**IN THE MATTER OF AN APPLICATION TO
AN BORD PLEANALA**

**For Approval of the Railway (Metrolink – Estuary to Charlemont via
Dublin Airport) Order [2022]**

ABP-314724-22

Schedule of Errata

Client	TII NTA	Project	METROLINK	Drawing Title	METROLINK - STRUCTURES CHARLEMONT STATION PROPOSED STREET LEVEL DESIGN	Drawing Status	S0
Consultant	JACOBS IDOM	Drawing N°	ML1-JAI-SRD-ROUT_XX-DR-Z-02090	Plan Drawing N°	ML-ST 307 O-A1		
		Scales Original Size A1	1:250			Sheet	1 of 6

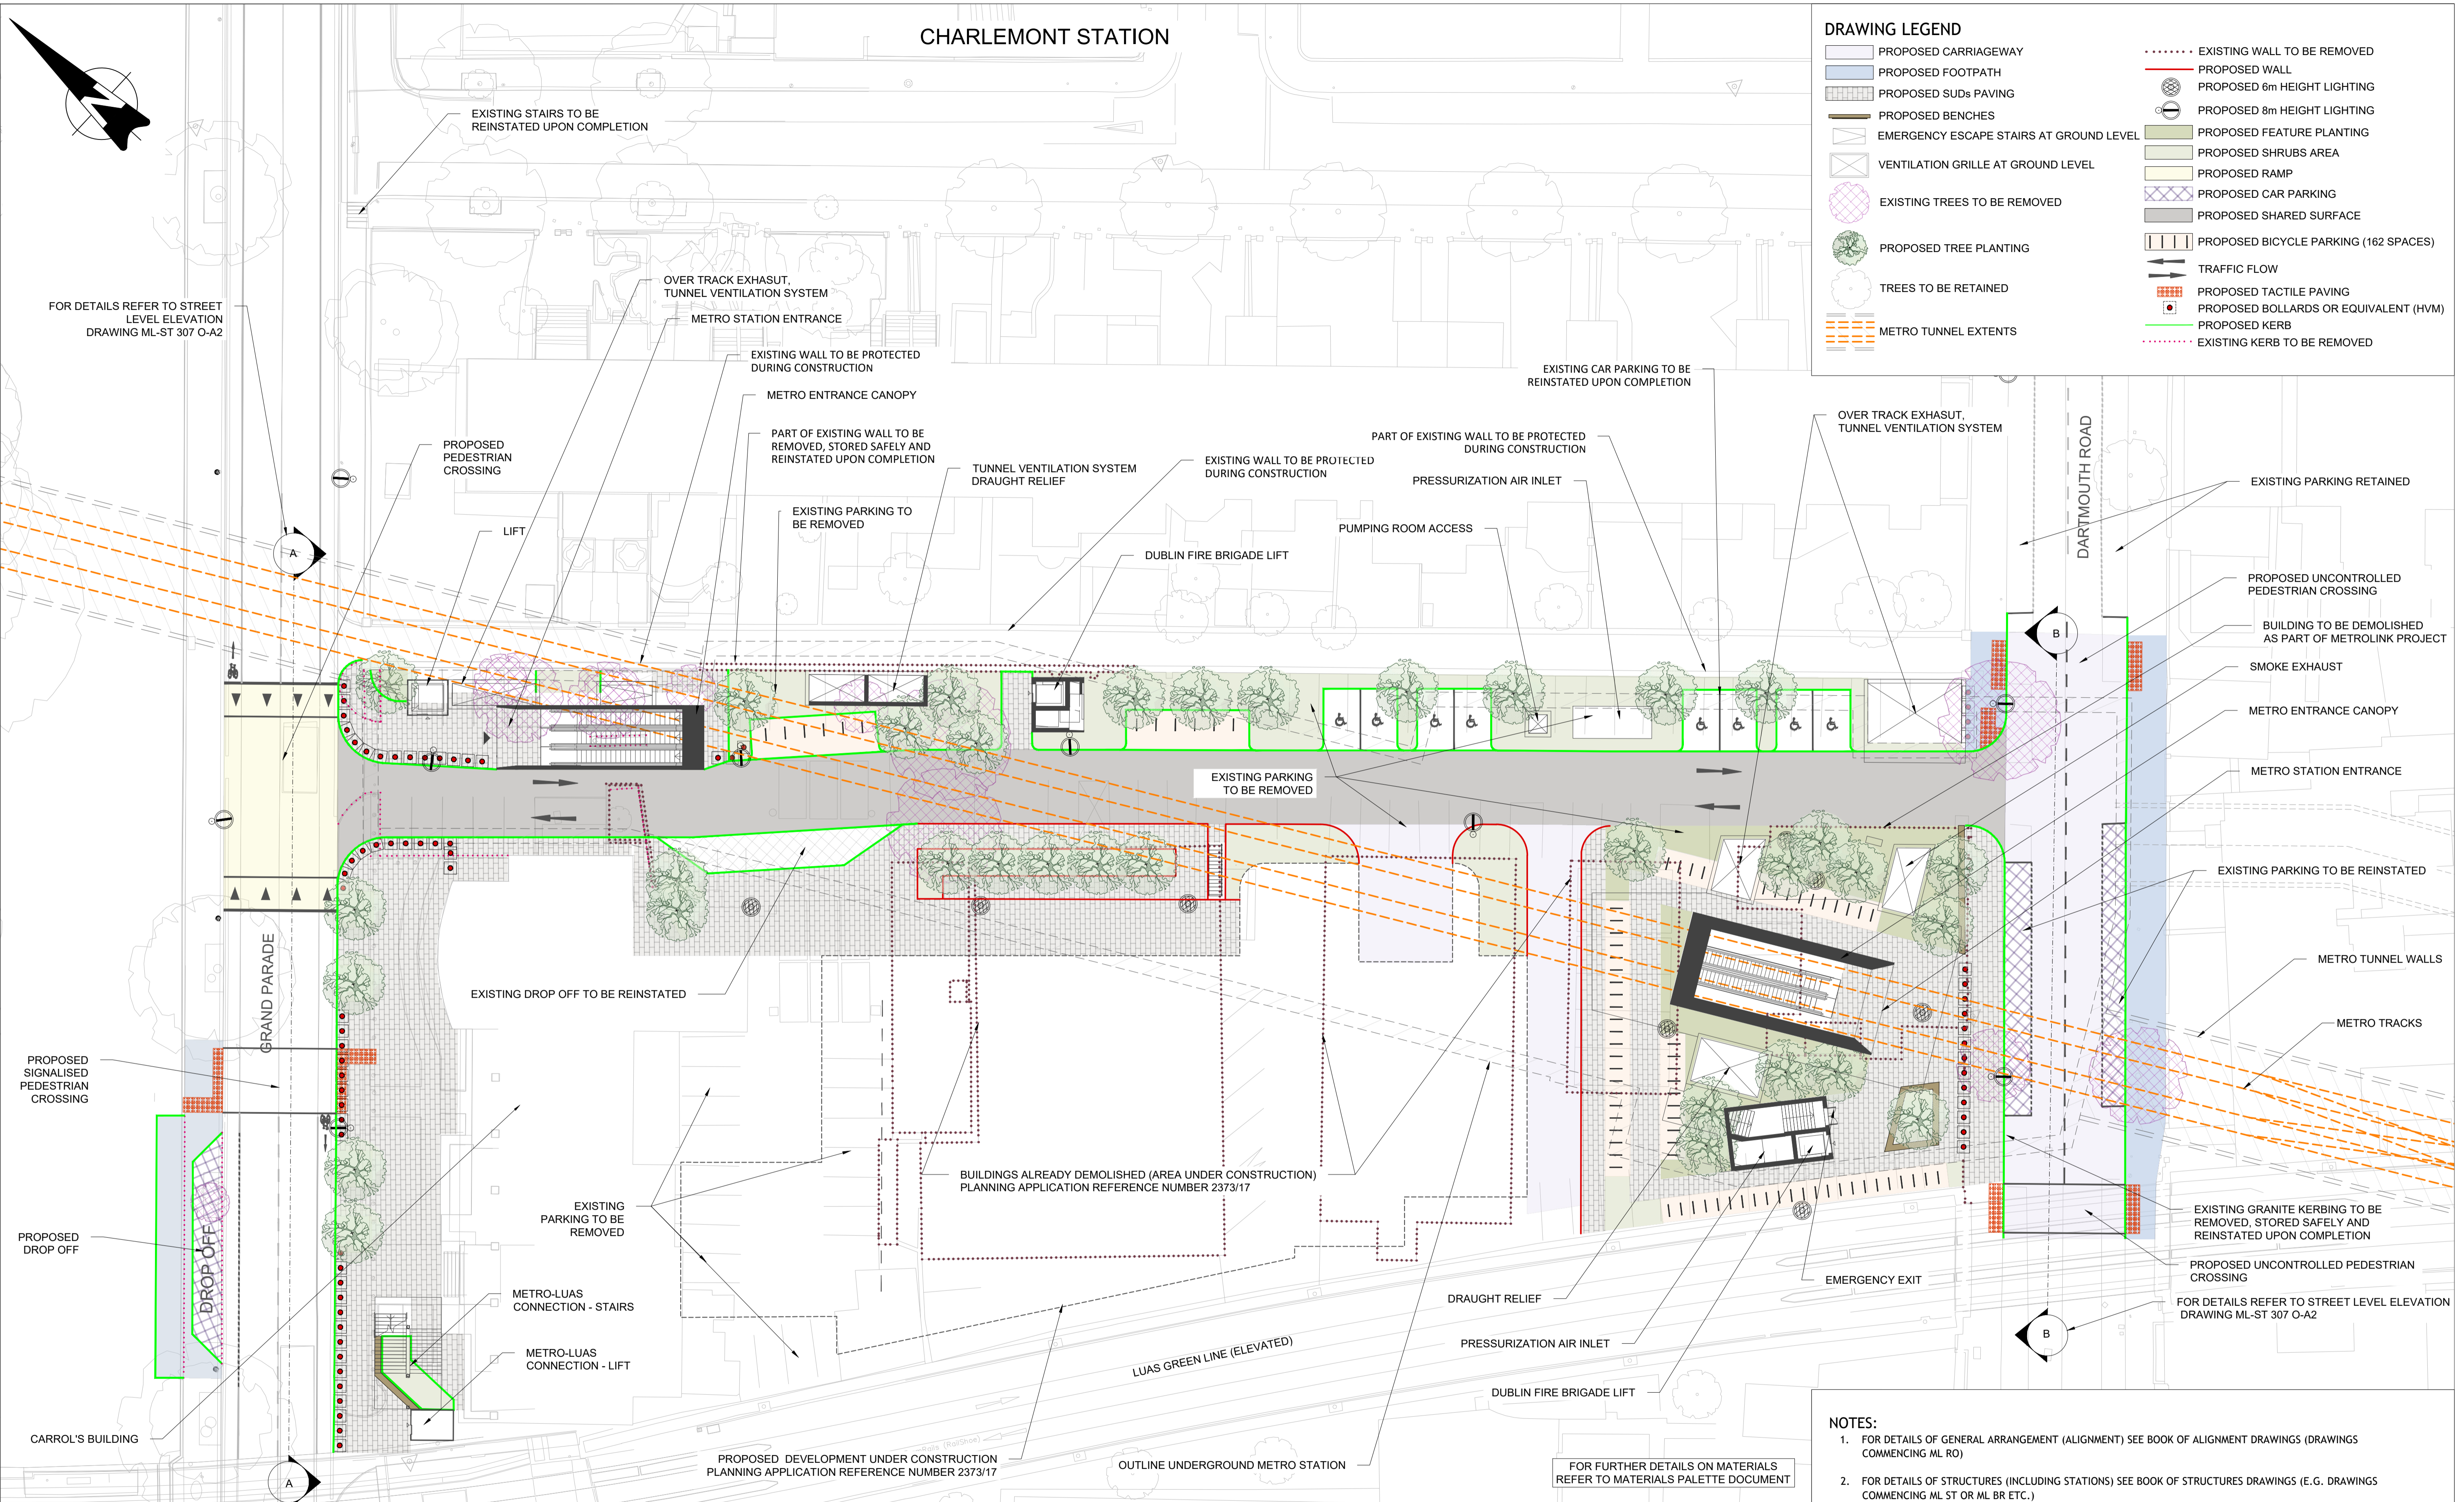
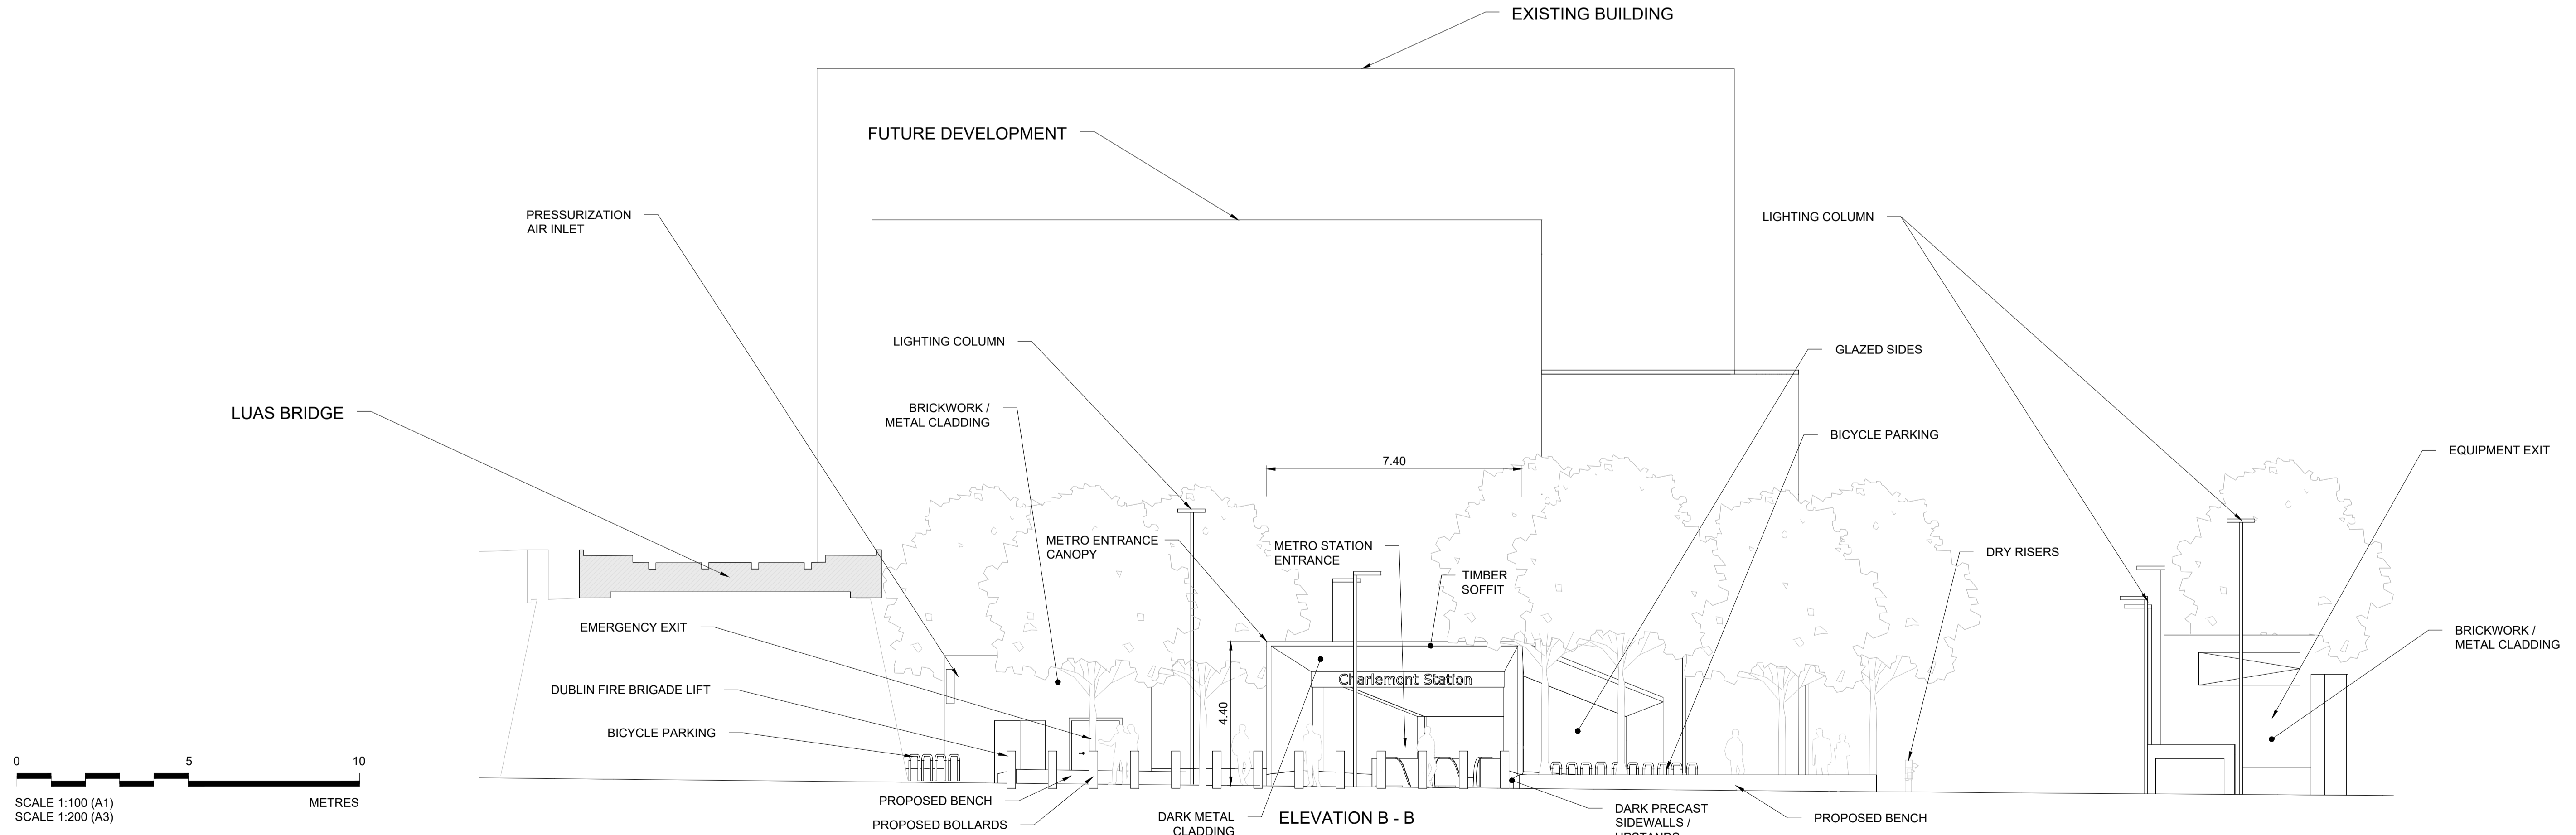
6.	Railway Order Plans/ Drawings	Structures Drawings Structures Details Book 2 of 3 MetroLink Stations Dublin City Council	54	Charlemont Structure Drawing ML1-JAI-SRD-ROUT_XX-DR-Y-02090 Width of PRM drop-off was incorrect.	Please refer to Drawing ML1-JAI-SRD-ROUT_XX-DR-Y-02090 in the Book of Updated Railway Order Drawings
